# A47 North Tuddenham to Easton Dualling

**Scheme Number: TR010038**

## **9.15 Alternative Wood Lane Junction Options Appraisal**

**ALTERNATIVE WOOD LANE JUNCTION OPTIONS APPRAISAL**

Figure 3.2 – Proposed Wood Lane Interchange

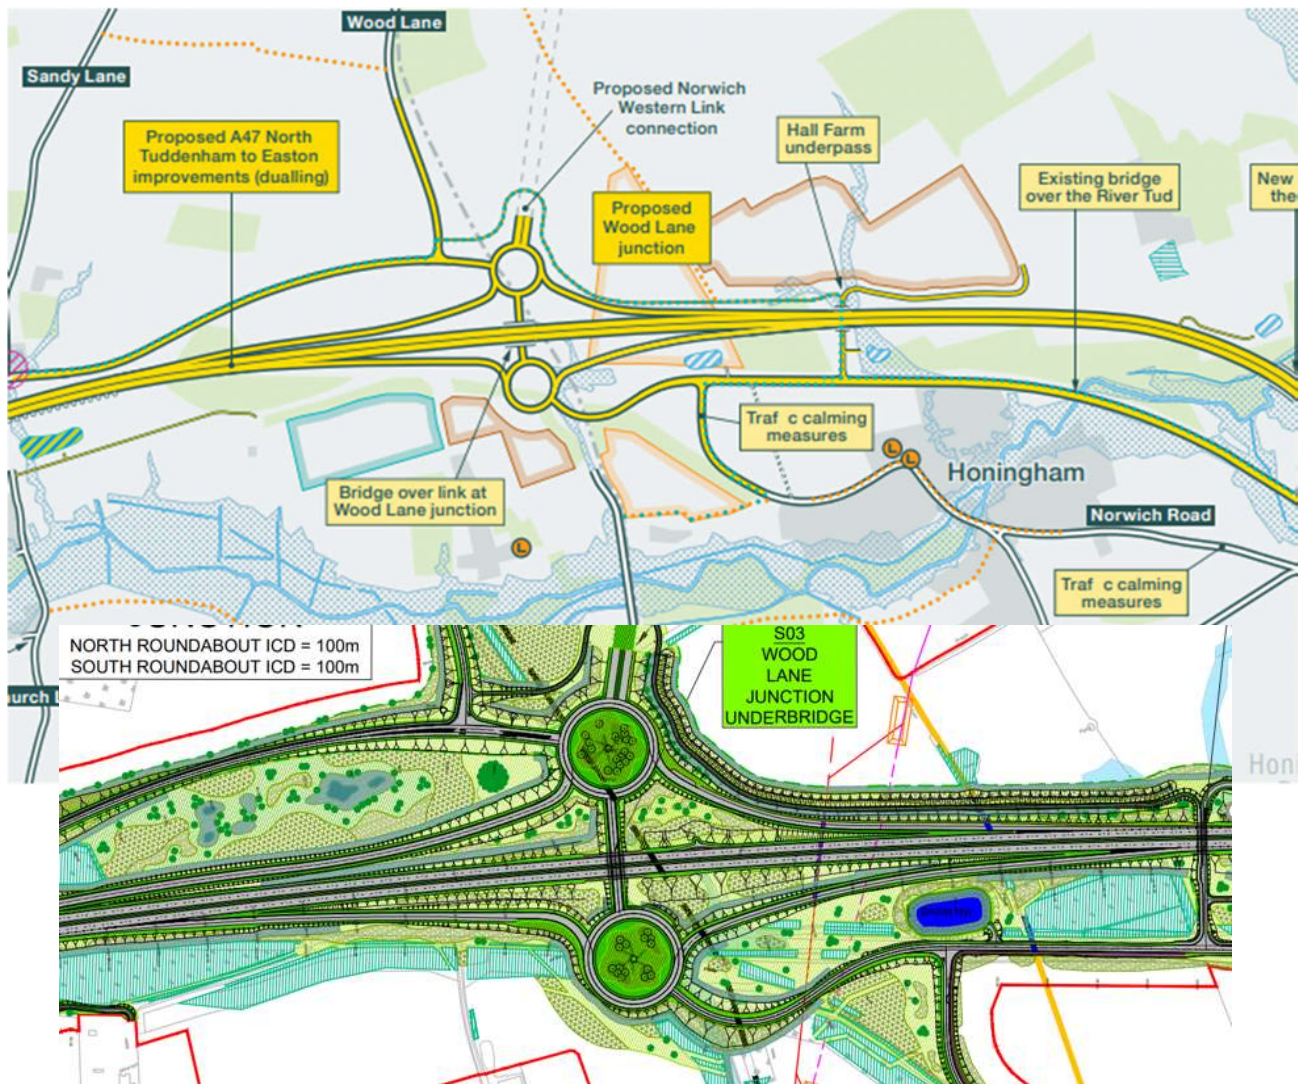
[3.3.113.3.13](#) The eastbound diverge and both merge slips within the Scheme design ensure the required stopping sight distance can be achieved on leaving and joining the main A47 dual carriageway. The required horizontal and vertical geometry are provided on junction slips to enable this.

[3.3.123.3.14](#) There is reduced stopping sight distance on approach to the westbound diverge slip and the eastbound diverge taper is to a Type A Option 1 Taper Diverge arrangement instead of the required Layout Type C Lane Drop (CD122, 3.26). More details are provided in Section 5 and Appendix A of this report.

Figure 4.1 – 2017 Preferred Route and Potential Alternative Mainline Alignment

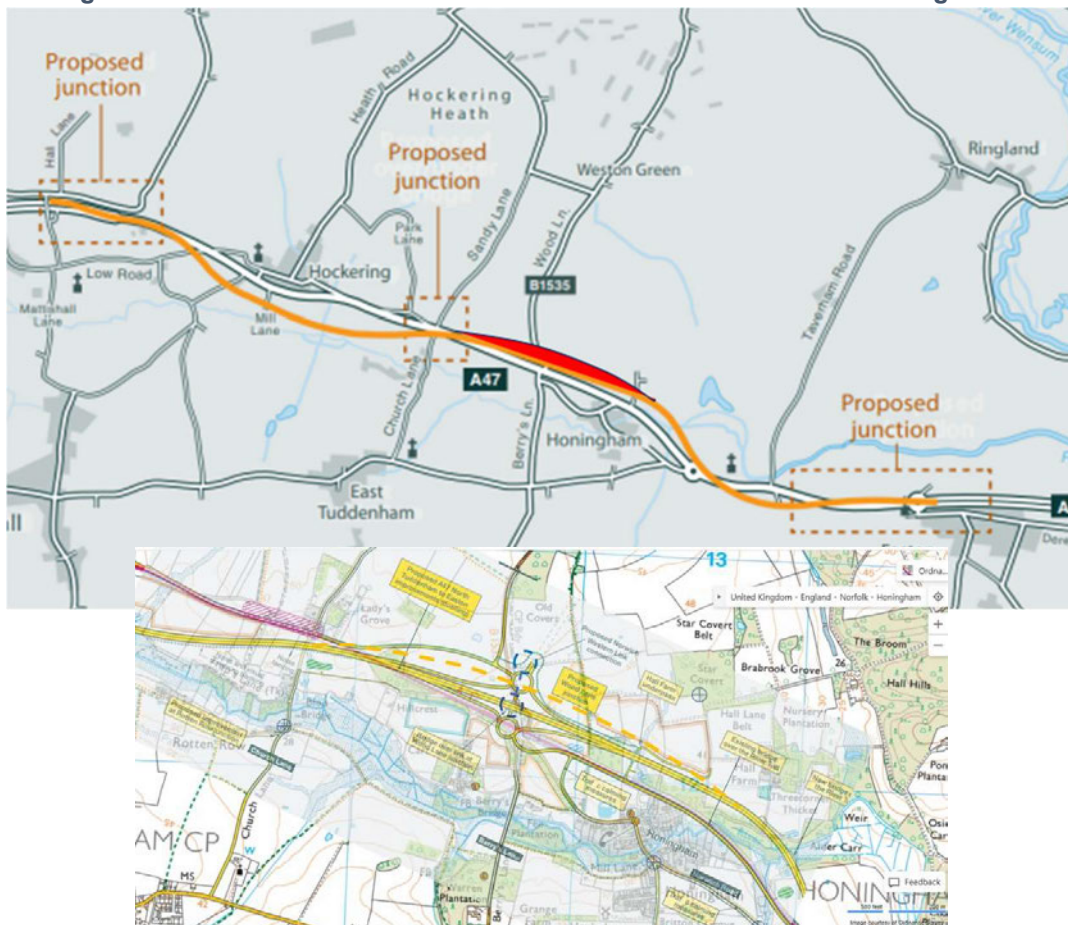
3.2.4 The mainline horizontal geometry shown is generally above the desirable minimum radius for a 120kph design speed and therefore complies with the required standards.

- 3.2.5 The exception to this is the 990m horizontal radius used at the eastern tie-in to the developed design. This falls one step below desirable minimum horizontal radius of 1,020m required of a 120kph design speed road and is therefore a horizontal relaxation.

- 3.2.6 As this relaxation occurs in advance of the junction diverge slip, widening to provide full stopping sight distance would be necessary to avoid this being classified as a “Departure from the standard” (CD 109, Clause 2.13).

- 3.2.7 This has not been accounted for in the alternative design and would increase permanent land take accordingly.
- 3.2.8 ~~It is also worth noting that~~ The new mainline alignment would be closer to residential properties at Hall Farm, thus increasing likely noise impacts for properties already predicted to experience a significant adverse residual noise effect during operation of the Scheme design; see Environmental Statement Chapter 11 Noise and Vibration (**APP-150**).
